REFUSAL OF PLANNING PERMISSION

APPLICATION NO. 2017/0480

Proposal Erection of detached garage

At 2 Church Street, Great Houghton, Barnsley, S72 0BL

PLAN AND ELEVATIONS

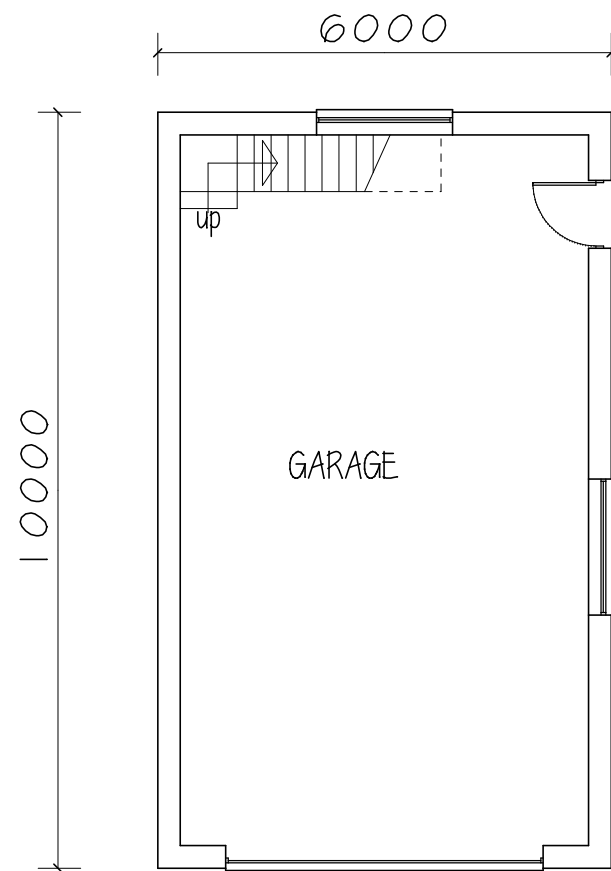
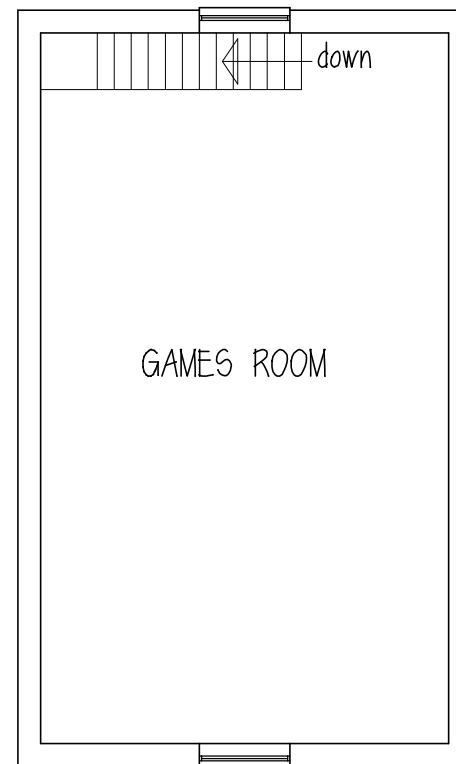
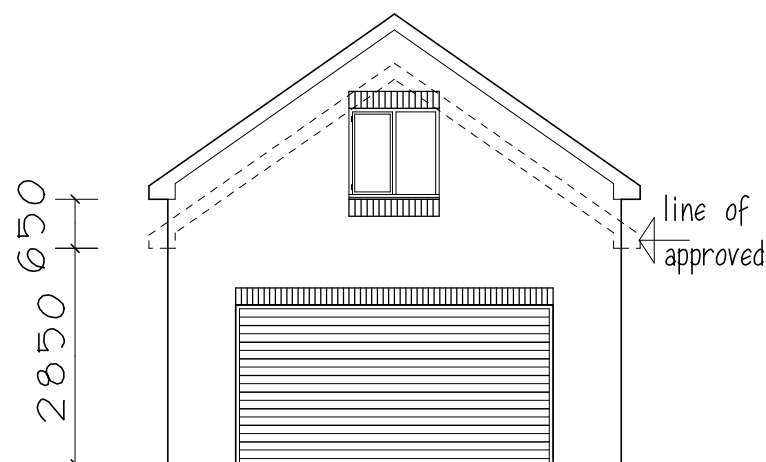
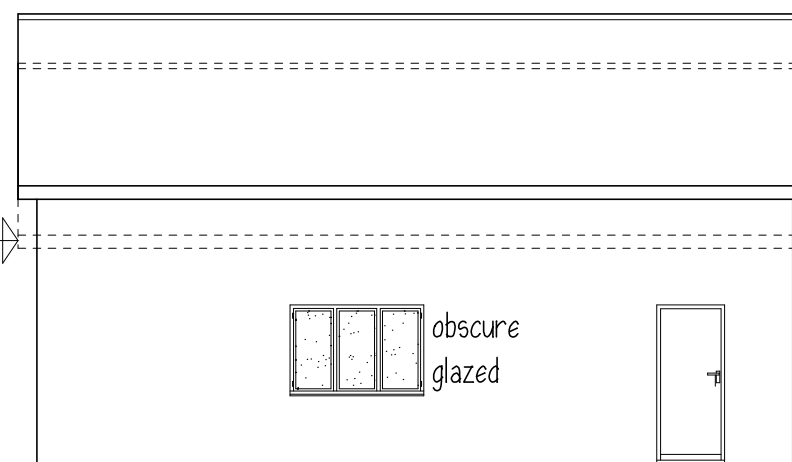
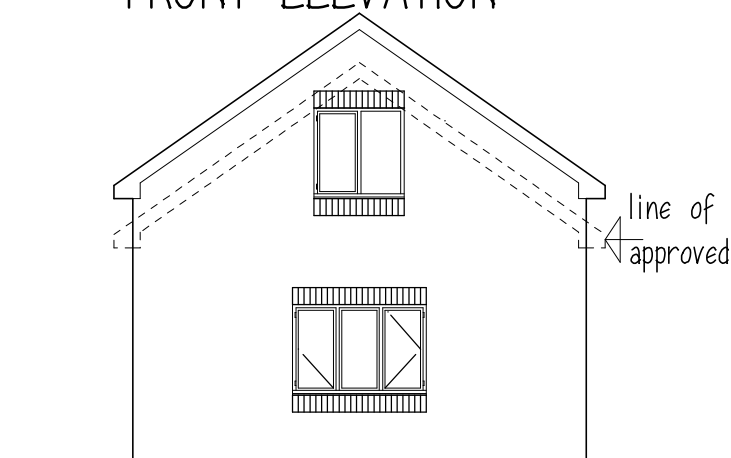
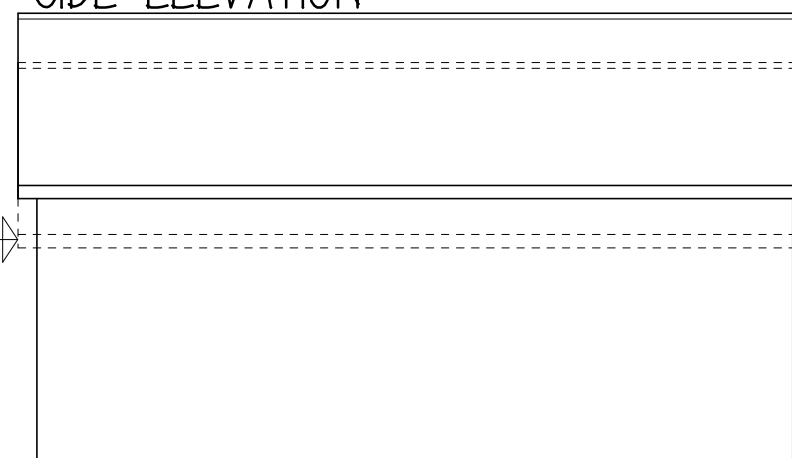
- 1 In the opinion of the Local Planning Authority the scale of the proposed garage is considered excessive in the context of the host dwelling and the character of the area. The garage would not appear as a subservient feature to the host dwelling and as such it would appear overly prominent to the detriment of the character and setting of the streetscene from which it would be seen. As such the proposals are considered to be contrary to Core Strategy Policy CSP 29 (Design), the design guidance contained within supplementary Planning Document - House Extensions. and the principles of good design contained within the NPPF.

- 2 In the opinion of the Local Planning Authority, the proposed garage, with a room at first floor, would be materially detrimental to the amenities of the occupants of the adjoining dwellings by reason of its overbearing and overshadowing impact, and impact on privacy, contrary to CSP29 and the Council's Supplementary Planning Document: House Extensions.
